11 April 2019

**Further Objections - Planning Statement and Street Scene
Ref Application FP/30/19/PL - 10 South Road, Felpham
Re-submission of FP/234/17/PL – Land to the rear of 10 South Road**

"SKETCH" PROPOSED STREET SCENE

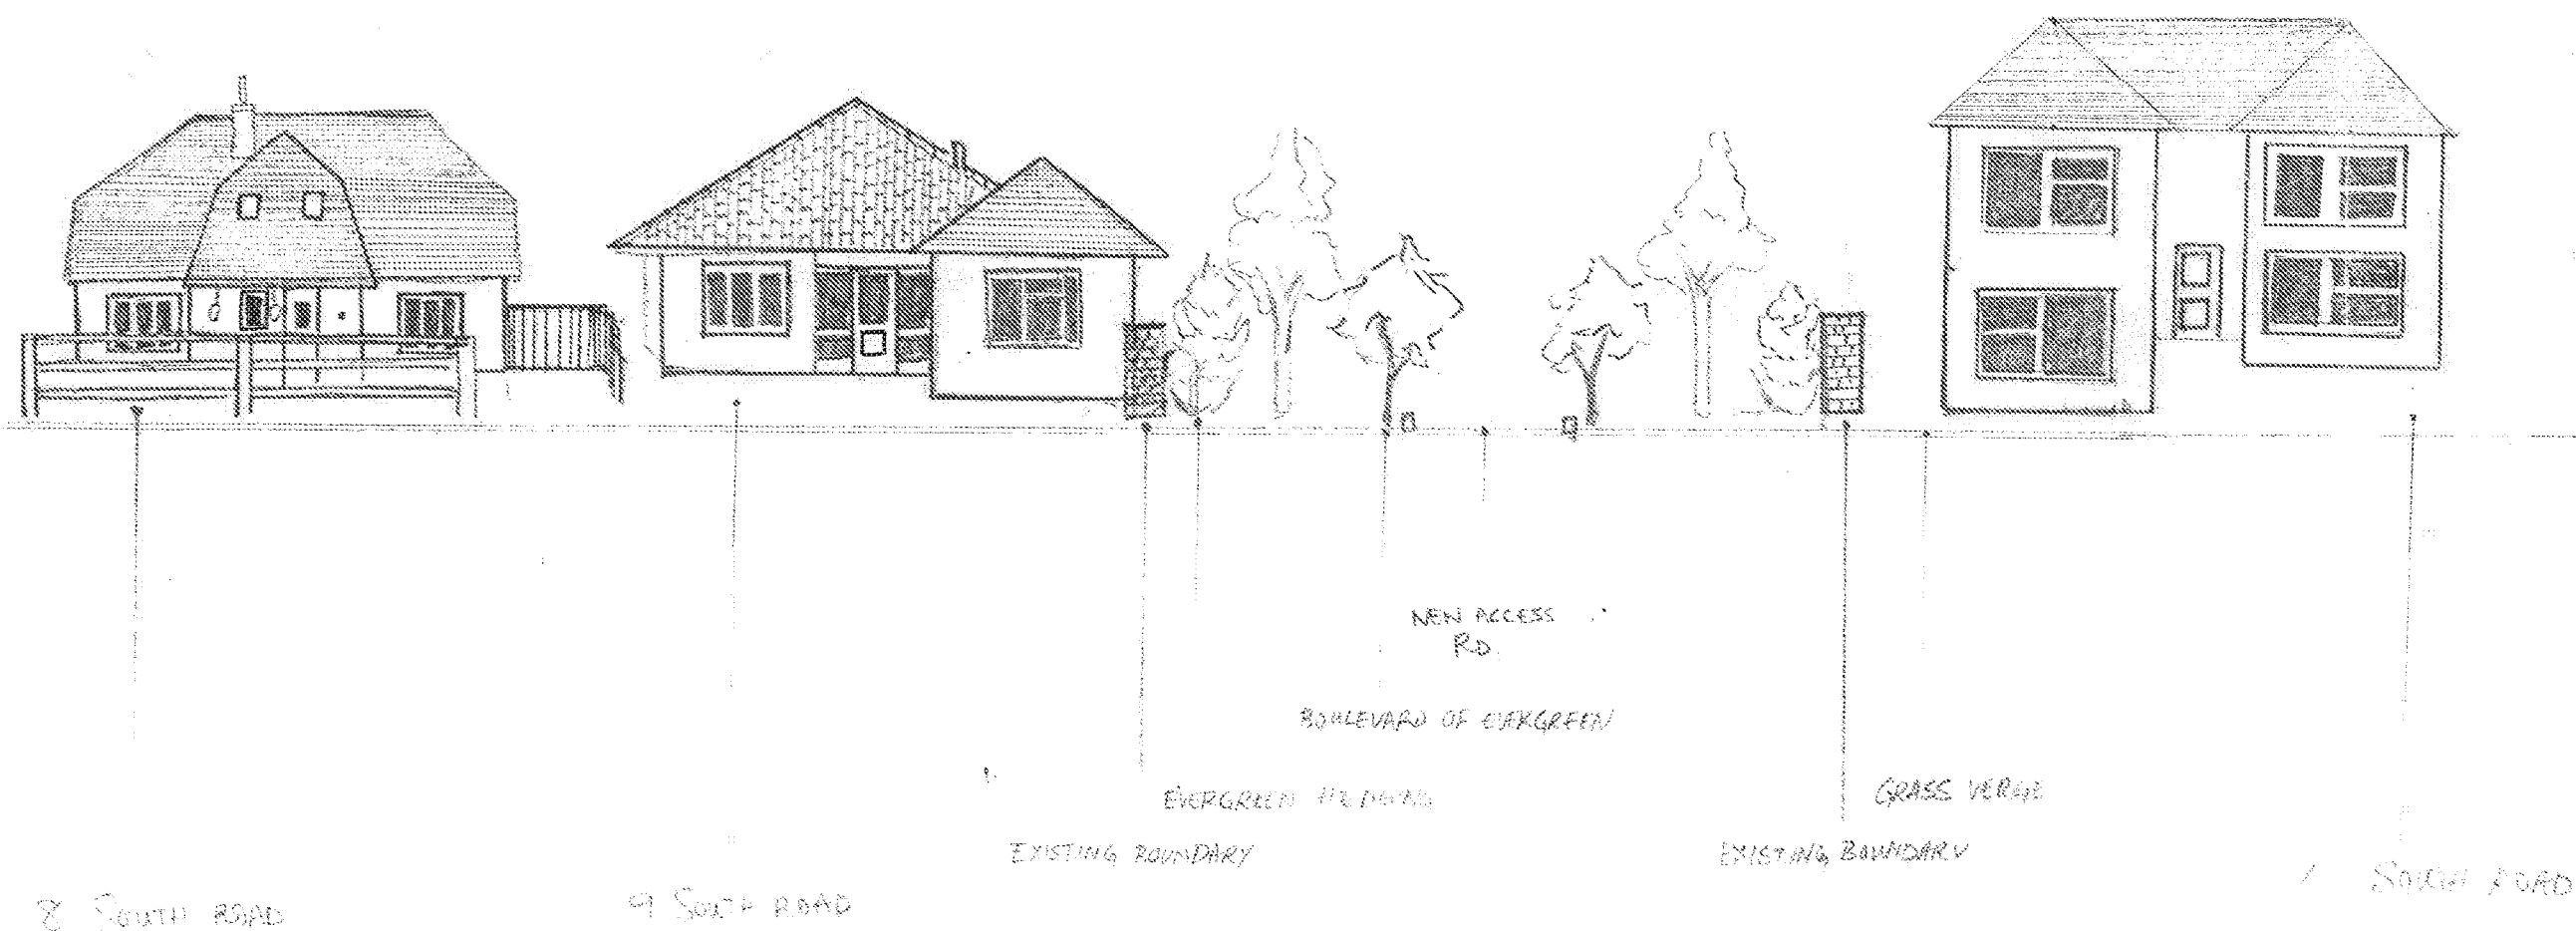
This sketch is **inaccurate and misleading**. It grossly misrepresents the depiction of Number 11 as it exists today, nor does it include the constructions (mentioned in the planning statement) being built in the drive, nor does it show the correct relationship between number 8 and 9, nor does it give an impression of what the view through would be. With all these major errors how can the drawing have any credible standing?
